Morgan and Morecambe Offshore Wind Farm: Transmission Assets

**Natural England's comments on Examining Authority's Written Questions (ExQ1) [PD-008]**

Planning Inspectorate Reference EN020028

07 July 2025

Figure 1 : Indicative Cross Section of the River Ribble Crossing (refer to the Onshore Works Plans (APP-154))

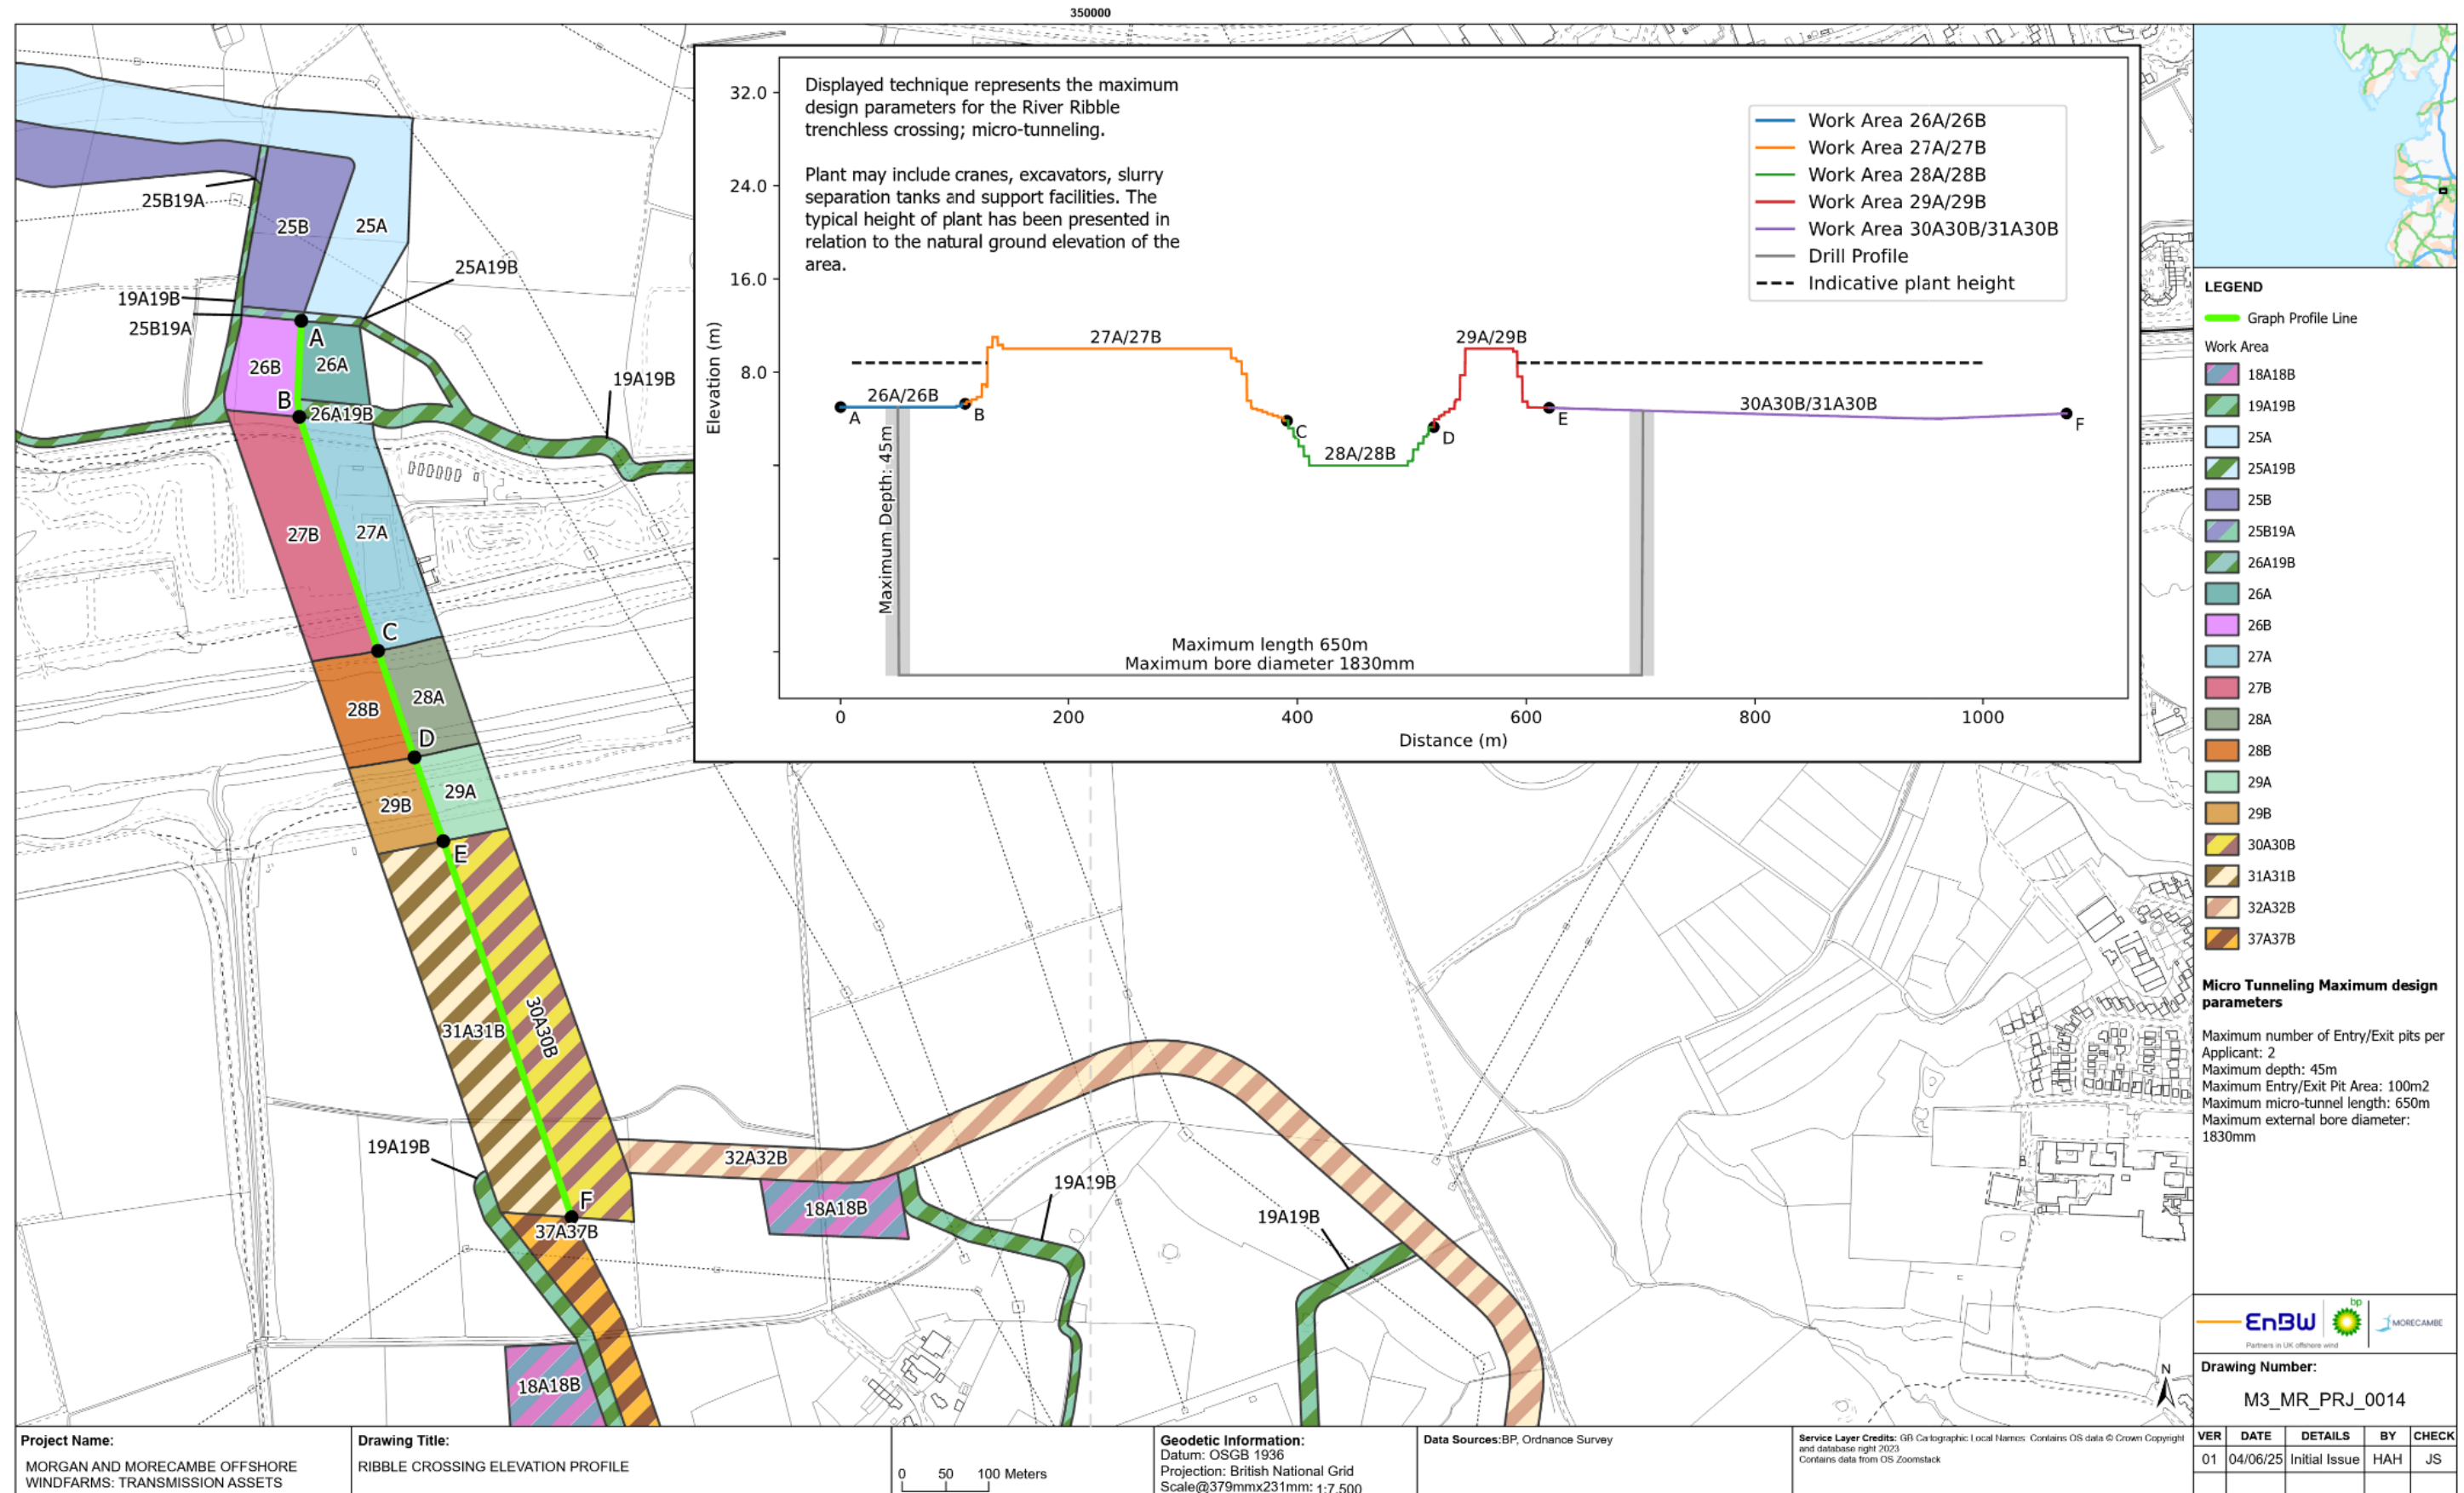
Q6.1.4	NE	<p><b>Technical notes</b>  At deadline 2 the applicants have submitted "Technical note on the energetics of the birds at landfall and the adequacy of the Fairhaven Saltmarsh" [REP2-045] and "Technical note on</p>	<p>REP2-044 provides sufficient information to resolve our comments relating to Newton Marsh SSSI and the River Ribble crossing. These updates are reflected in tab H of the Risk and Issues Log submitted at D3 (Appendix K).</p>

Newton Marsh SSSI and River Ribble Crossing” [REP2-044]. Can you confirm if the information in those notes resolves outstanding relevant issues in the Risk and Issues Log [REP2-063].	As noted above, our review of REP2-045 is ongoing.
Q6.1.5	NE, Lancashire County Council (LCC), Fylde Borough Council (FBC) and any other IP	<p><b>Protected species - sand dunes habitat surveys</b></p> <p>In chapter 3 of the Environmental Statement: Onshore ecology and nature conservation [APP-075], it is stated that further surveys are not considered necessary for the transmission assets due to existing survey information available being sufficient to assess the potential impacts to the species.</p> <p>Why is existing available survey information (Fylde Sand Dune Project Steering Group) not considered enough to establish a baseline?</p>	<p>Natural England is unable to advise further on the sufficiency/robustness of the evidence until further Metadata is provided to inform the impacts of development on the Species</p> <p>This is because the data used to interpret sand lizard distribution is reliant on a heat map compiled by data collected from focal observations by Fylde Sand Dune Project Steering Group, though the raw data has not been included within Annex 3.8: Great crested newt and reptile survey technical report [APP-082].</p> <p>Additional information should include timings and experience/knowledge of those conducting the surveys and collecting data.</p> <p>Reptile data from refugia would not be accepted as a reliable method of collecting data on sand lizard presence/distribution/population size.</p> <p>Natural England also notes that the sand dunes at Lytham are accreting (see <i>Skelcher 2024 “A review of ecological change in relation to management interventions undertaken on the Fylde Sand Dunes Project, Lancashire final report”</i>) which shows in Maps 2 &amp; 3 increases in frontal dunes achieved through accretion management. The report also contains images of the frontal dunes which are Marram and Lyme Grass dominated with a good proportion of bare sand which is</p>
